# PINE VIEW ESTATES FILING NO. 1

## STREET PLANS

PCD FILE NOS: SF-2019 SP-204

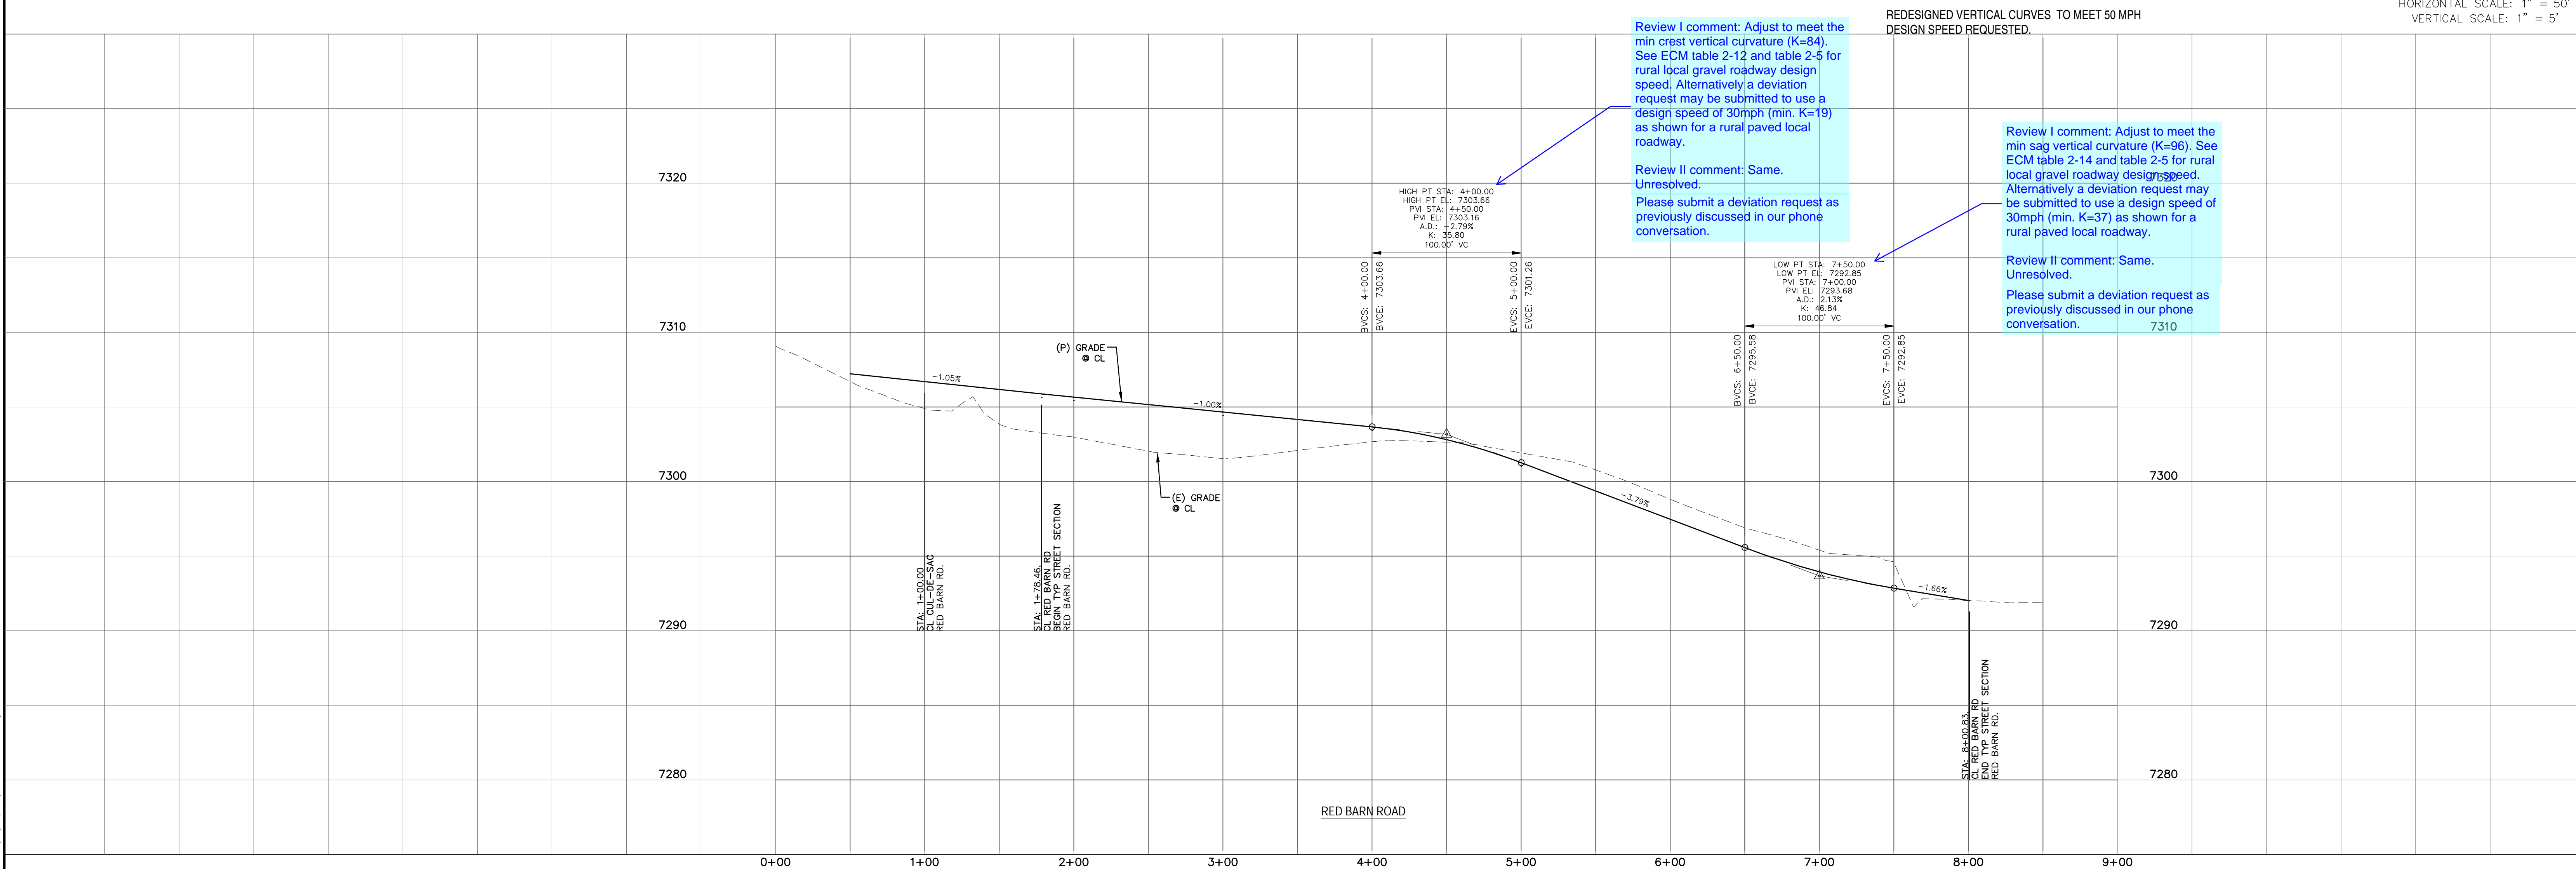
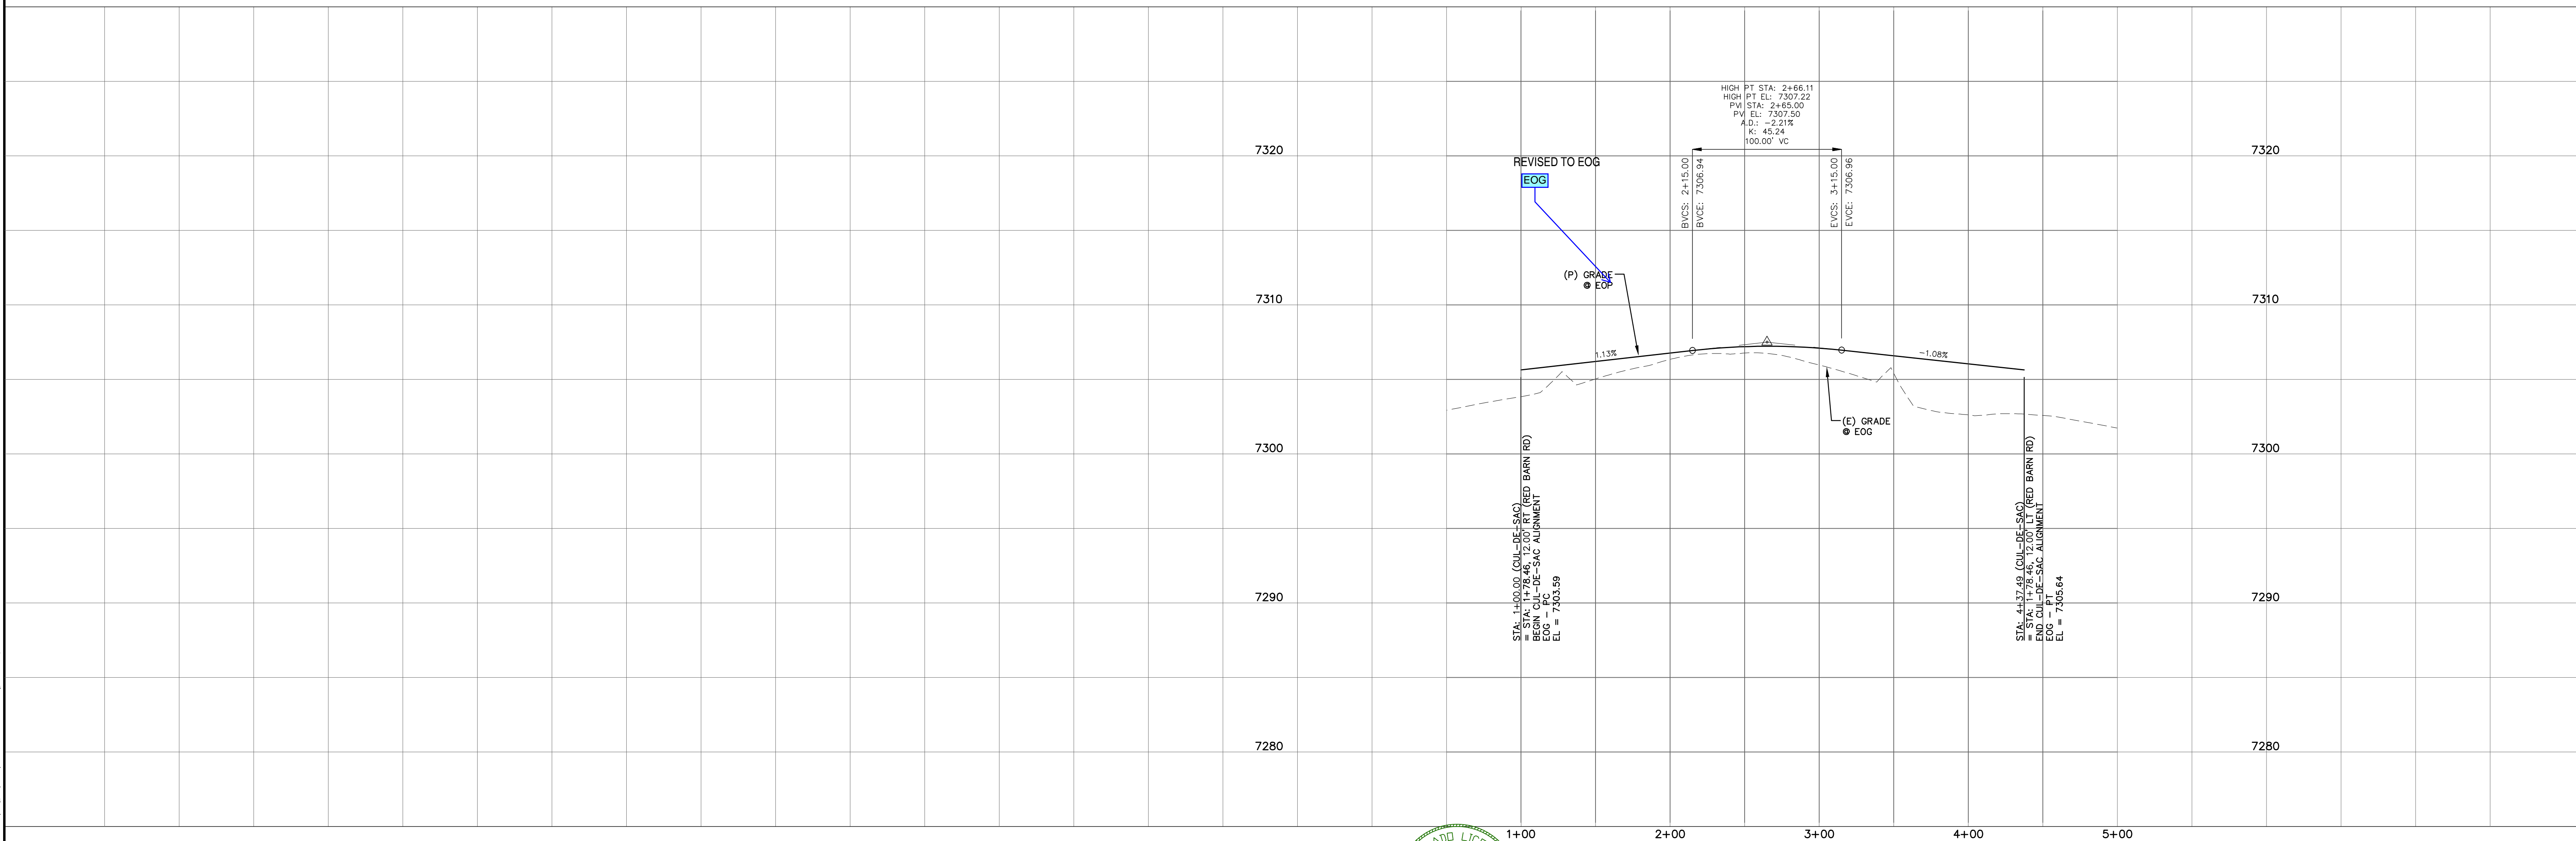
6:1 per county standard detail

Please label as RURAL GRAVEL LOCAL. Please also revise the title on the cross section detail on the GEC
